CITY OF ALBUQUERQUE

April 28, 2021

Re: JB Hendrson Fabrication Facility
10200 Bell Ave. SE
Traffic Circulation Layout
Architect's Stamp 01-15-2021 (L21-D075)

AS-101

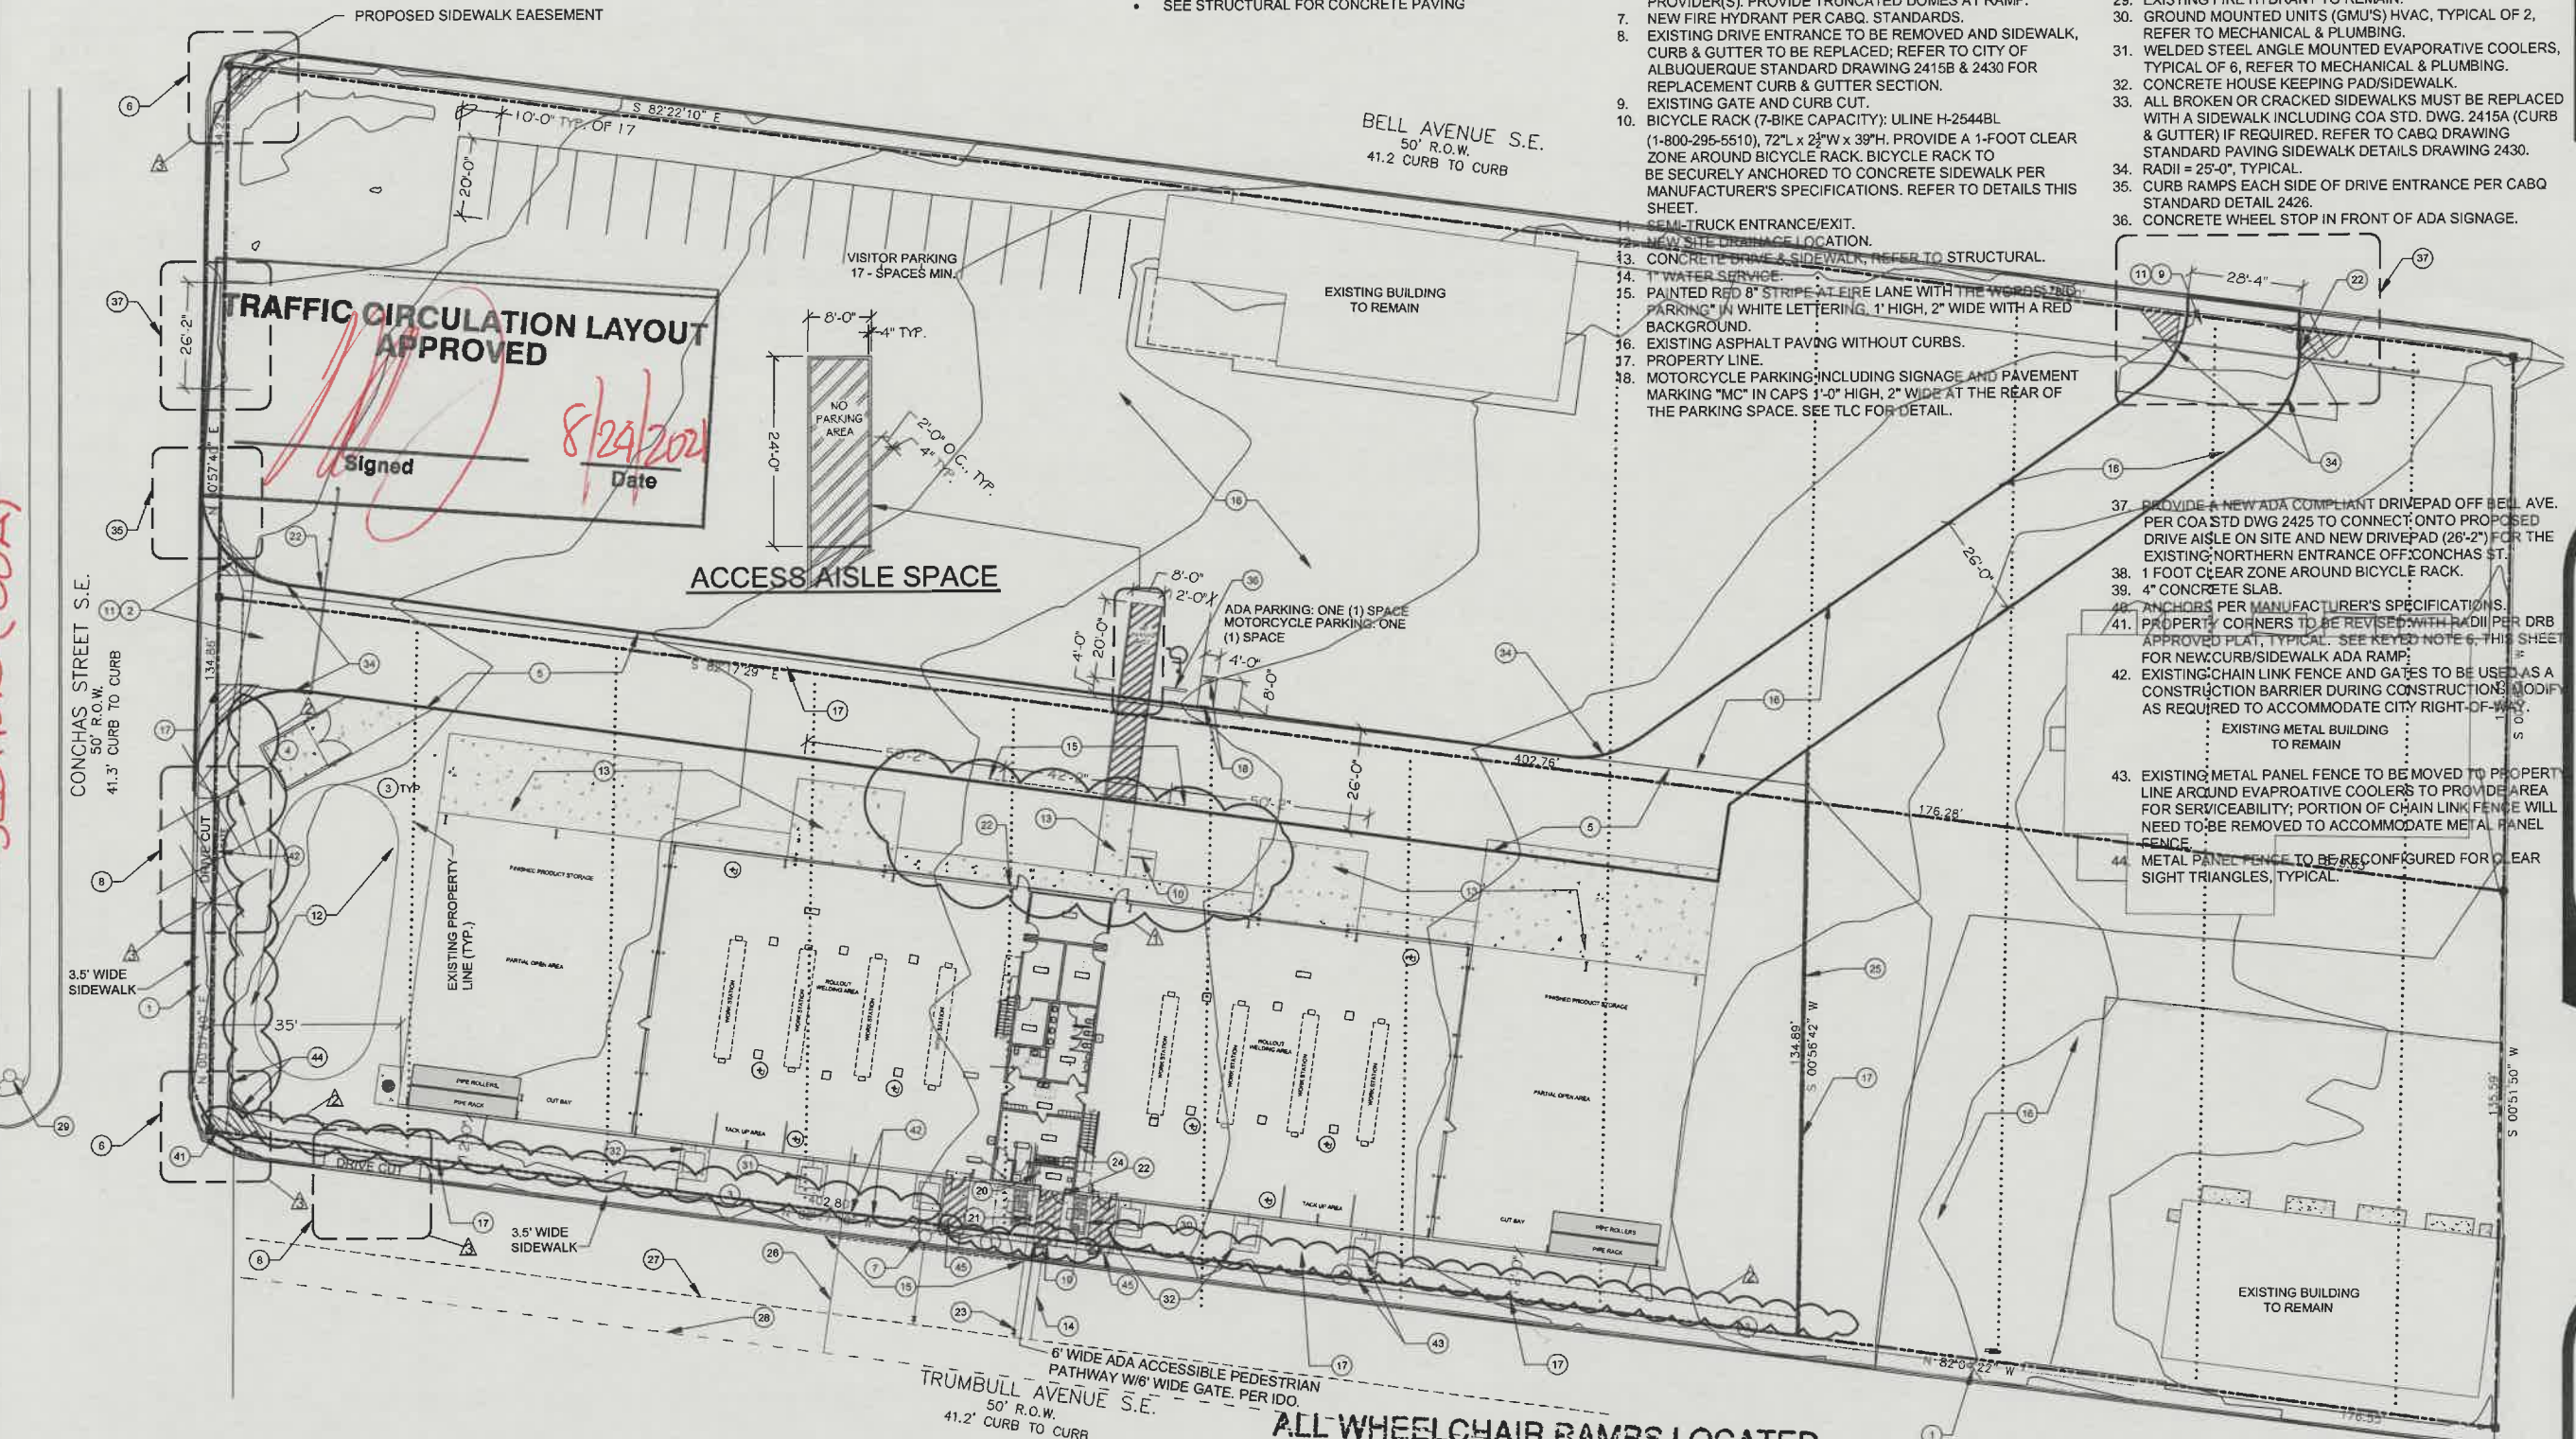
1. **Reference notes for striping and/or pavement markings:** Called out on Civil sheet will need (DETAIL) to be provided on AS-101.
2. Drive aisle connection off Bell Ave. and Conchas St: **Provide a new ADA compliant drivepad off Bell Ave. per COA std dwg 2425** to connect onto proposed drive aisle on site and New drivepad (26' -2") for the existing northern entrance off Conchas St.

6. **Key Note(AS-101) 6:** Add Truncated domes to the note.
7. **Key Note 33:** Add COA std dwg 2415A (curb & gutter).
8. **Key Note 15:** Add the Clear Sight Triangle to the northern side of proposed entrance drive (not shown) and at the corner of Bell Ave and Conchas St (not shown).

10. **Key Note 2(AS-101) :** Add COA std dwg 2525 (proposed drivepad) and 2420 (6 ft valley gutter) for proposed new entrance at the 26 ft access off Conchas Sreet.

- 15. Show all drive aisle widths and radii. Some dimensions are not shown.
 - 16. **Note needs to be provided for this condition:** Per the IDO, a 6 ft. wide ADA accessible pedestrian pathway is required from the public sidewalk to the building entrances. **Please clearly show this pathway and provide details** off Trumbull and if gate exists show a clear 6 ft width gate.

TCL

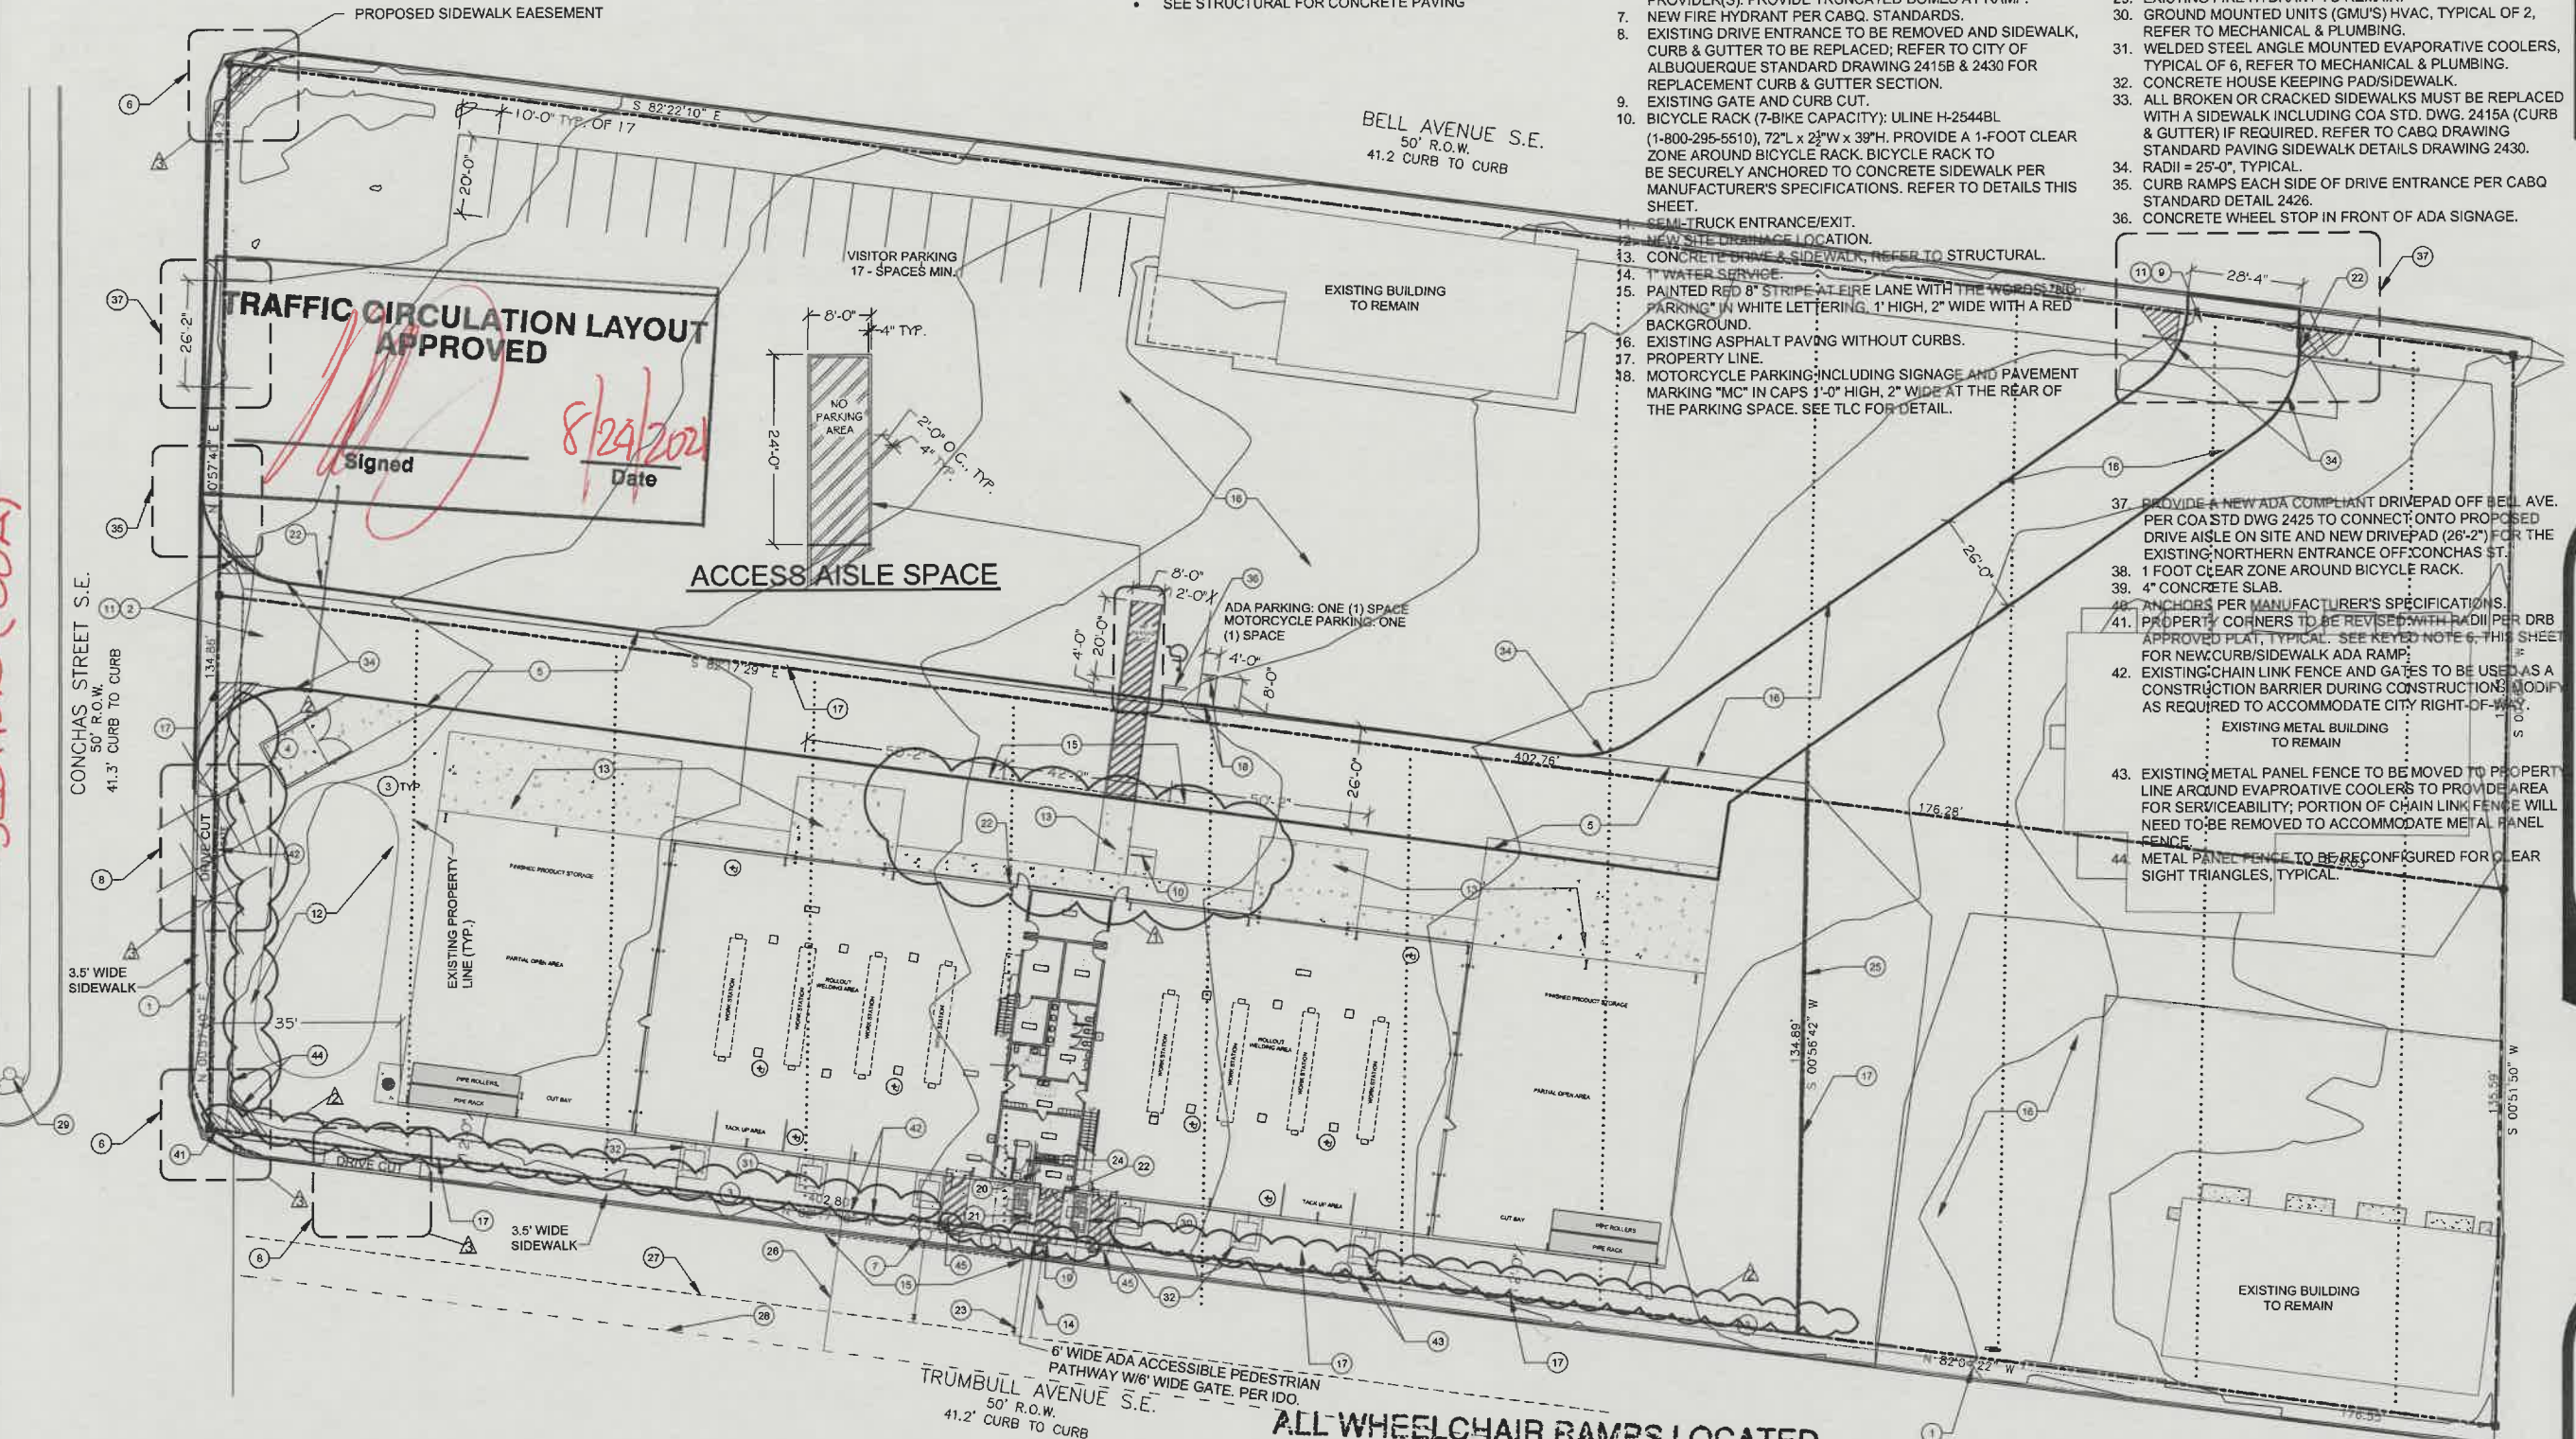
3. Identify all existing access easements and rights of way width dimensions. **Will need to provide an approved Plat prior to TCL approval.**
4. Identify the **right of way width**, medians, **curb cuts**, and **street widths** on Bell Ave, Congas St., and Trumbull Ave. **Please provide all information from plat onto TCL sheets (TCL/ AS-101).**

- 17. Any private structures that are located within public right-of-way such as **gate/door, fences** and walls shall either be removed or else a revocable permit with the City is required in which an annual fee is paid per year, based on square footage of the encroachment. **A gate and fence is shown on public ROW off Trumbull Ave (Sheet TCL). It needs to be relocated onto private property.**
